Zoning Division  
Marge Schmuckal  
Zoning Administrator

August 28, 1998

RE: 178 Dartmouth Street - 81-A-1 & 2 R-5 Zone

ADDRESS: 178 DARTMOUTH ST INSPECTION DATE: 3-27-98
PORTLAND, ME SCALE: 1" = 30'

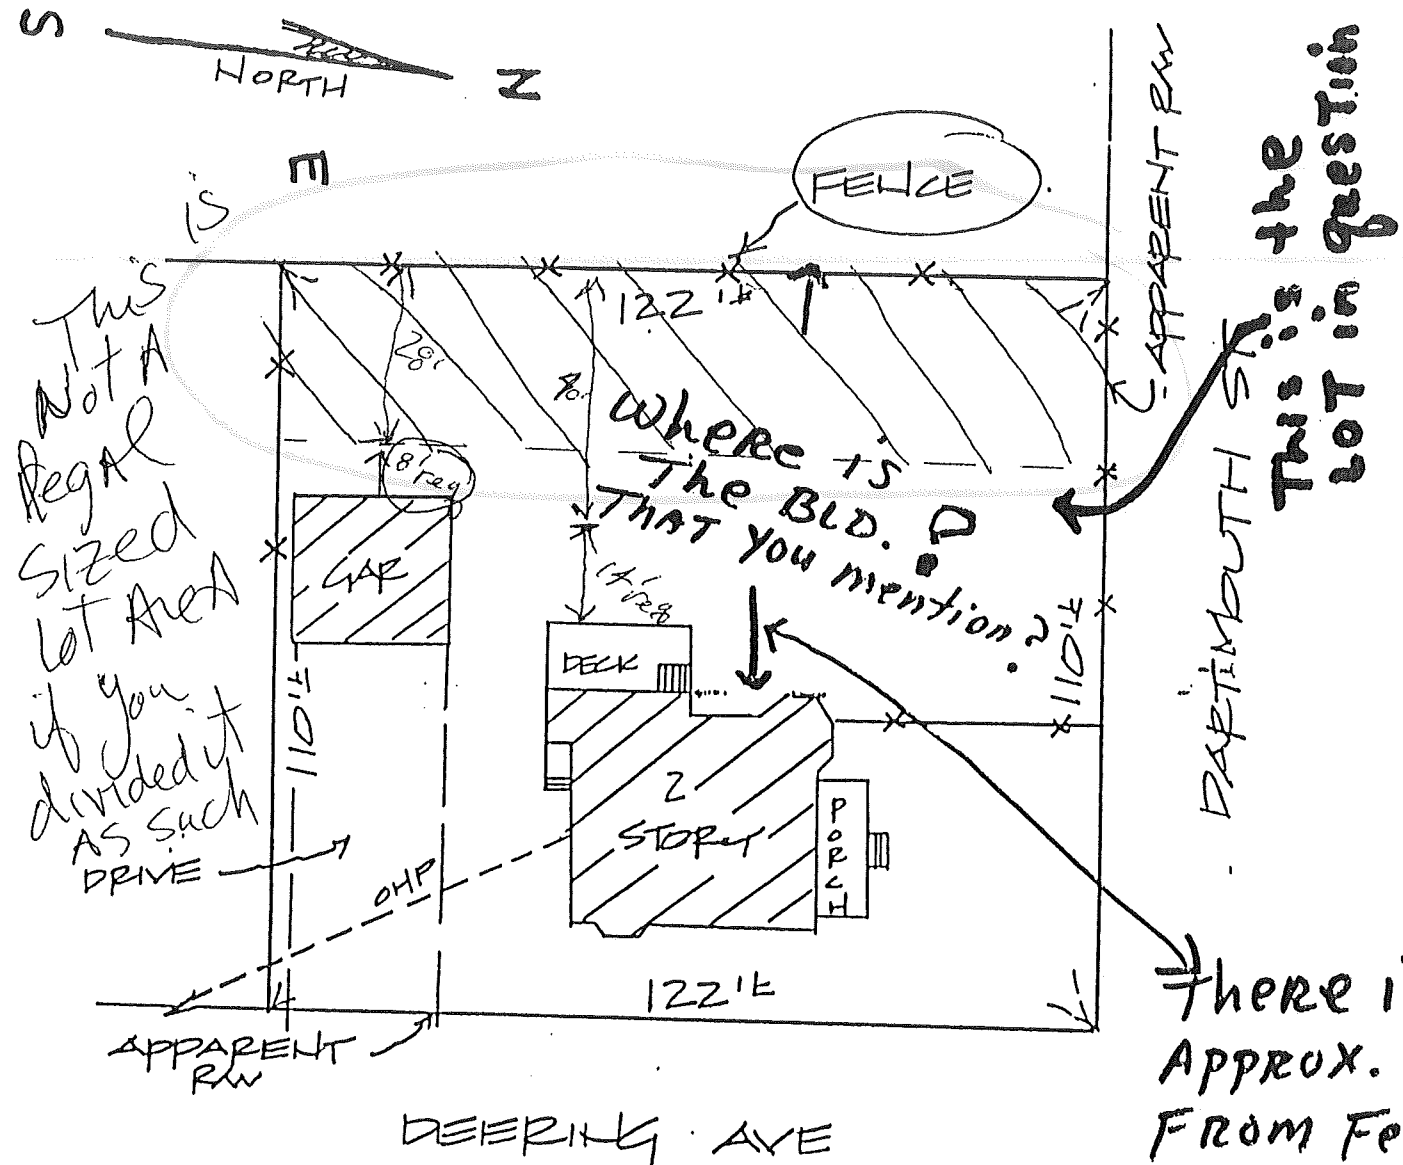
This is Not A legal sized lot Area if you divided it AS SUCH DRIVE

Also There is a 60' lot width requirement - At least 120 would be needed along with proper setbacks

I'm sorry that my previous letter did not answer every one of your questions concerning your property. However, your basic question concerning your lot was whether you could divide your present lot and create a new, additional lot. As I stated in my previous letter, you can not. I used the survey that you included in order to determine this. You are in an R-5 residential zone. You would need to meet all the standards of the R-5 zone (lot size, setbacks etc.) for the original lot and a newly created lot. Your survey shows me that it would not be possible. I have included a copy of the R-5 zone for your reference. It has all the specifics you requested.
